Submission ID: 6642

The Examining Authority (ExA) is requested to review the Applicant's response to ExQ1 Question 1.12.13 (Existing A417) in conjunction with RR058 and, consider if the Applicant will address the legacy issues of drainage and excess ground water detailed in this Relevant Representation that arose following the construction of the existing A417.

Drawing Title: **FIGURE 13.19 SCHEME HIGHWAY DRAINAGE - PLAN**

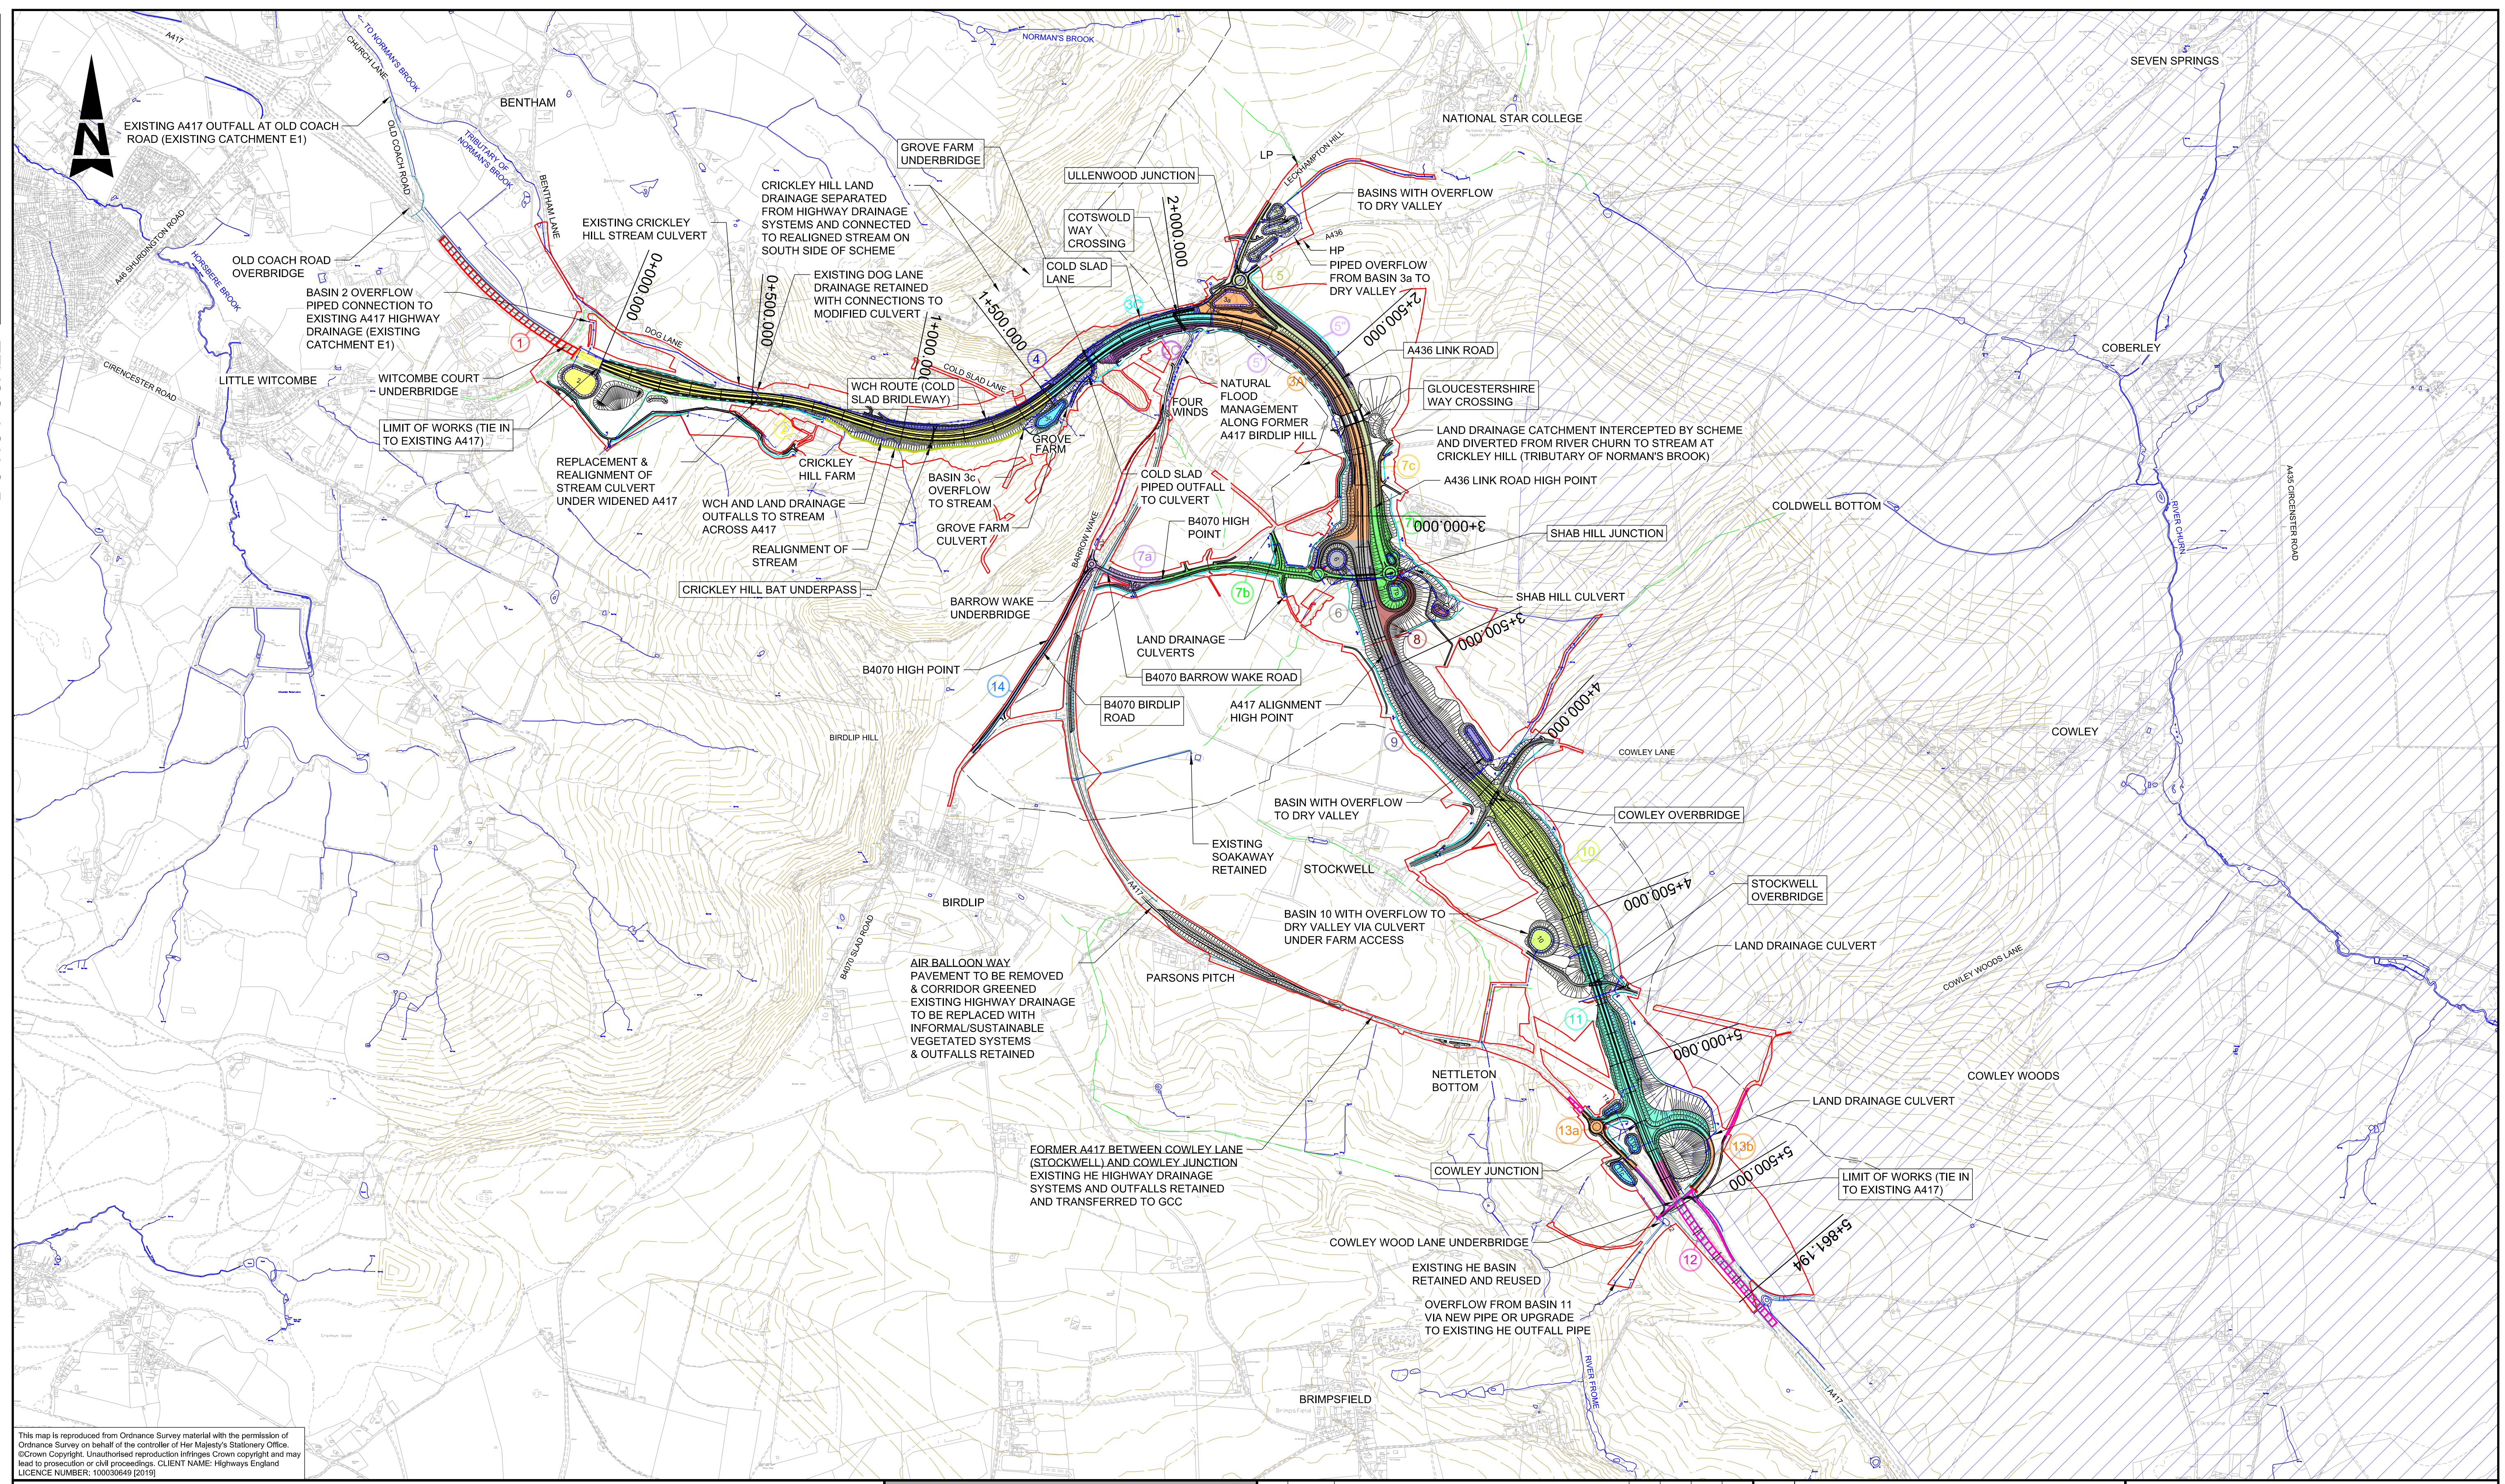
Furthermore, the ExA is asked to require that any drainage works planned for the repurposing of the A417 will not further impact negatively the property referenced in RR058 and that actions will be taken to satisfactorily correct the current legacy issues with drainage and ground water.
